**Our Ref: EP/168/19/PL**

**Town & Country Planning Act 1990 (as amended)  
Town and Country Planning (Development Management Procedure) (England) Order 2015  
Application for Planning Permission**

**Development** 1 no. dwelling & alterations to roof of existing dwelling (4 Beechlands Cottages) including the provision of new dormer to front elevation.  
**Location** 4 Beechlands Cottages and land adjacent Beechlands Close East Preston

Location Plan

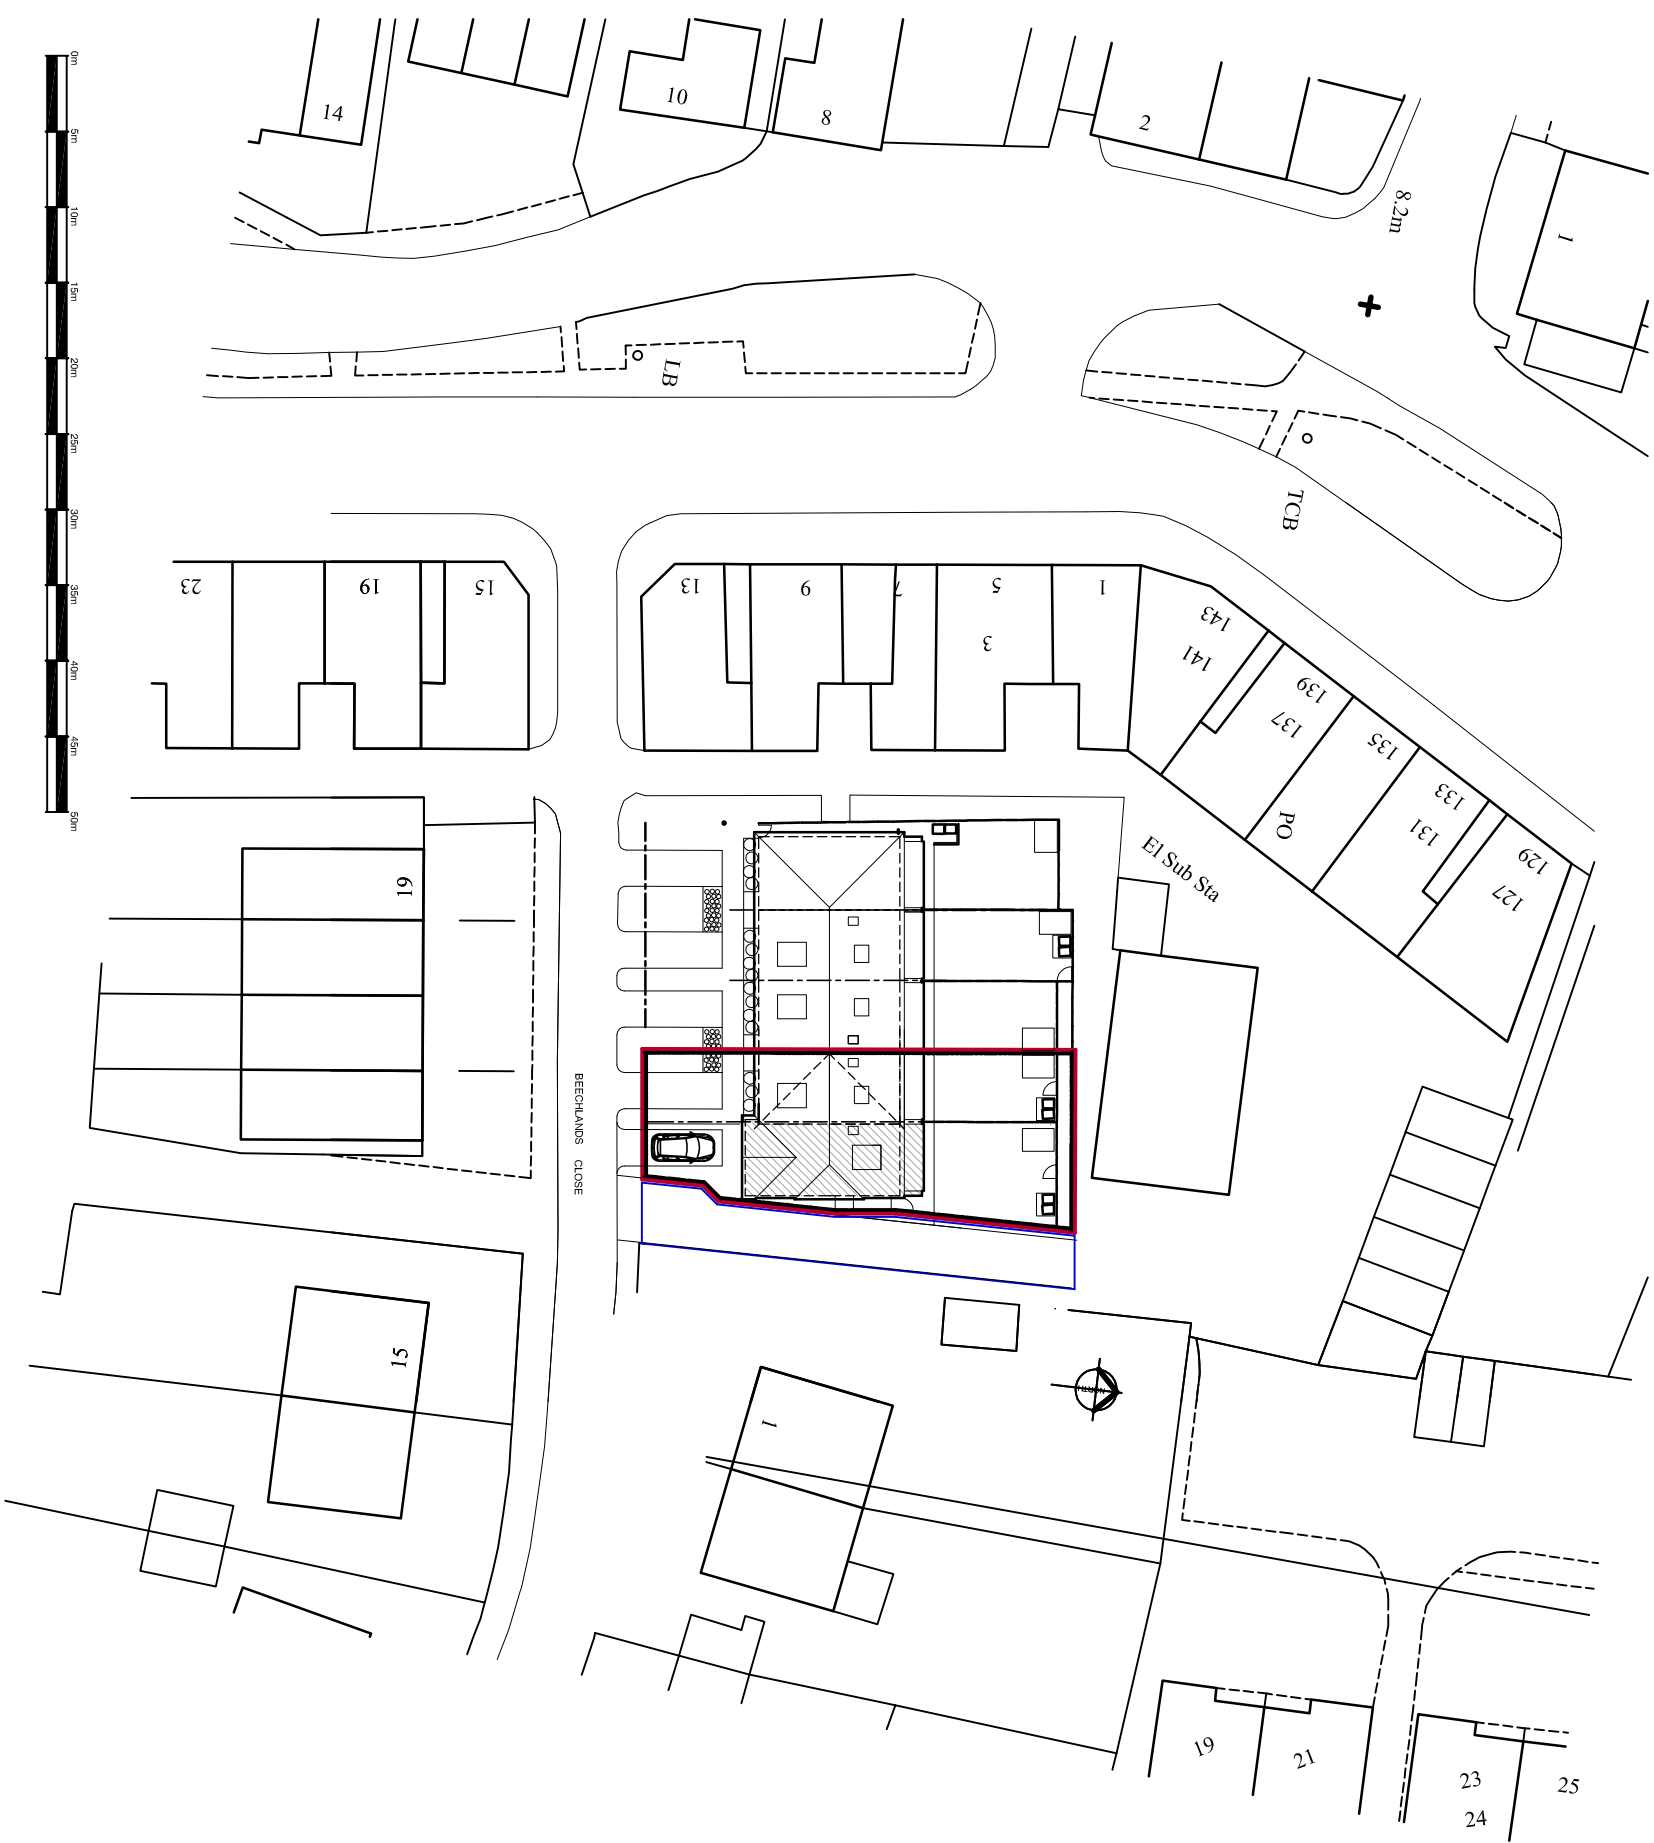
Location Plan

Please submit 1 electronic or 3 paper copies of an amended location plan to include the access point.

If this includes West Sussex County Council land, you will need to complete Certificate B and serve notice on WSCC.

Block Plan

Please submit 1 electronic or 3 paper copies of an amended block plan showing the measurements to the boundaries and the proposed works clearly highlighted on the existing dwelling. This must also show the new access & visibility splays.
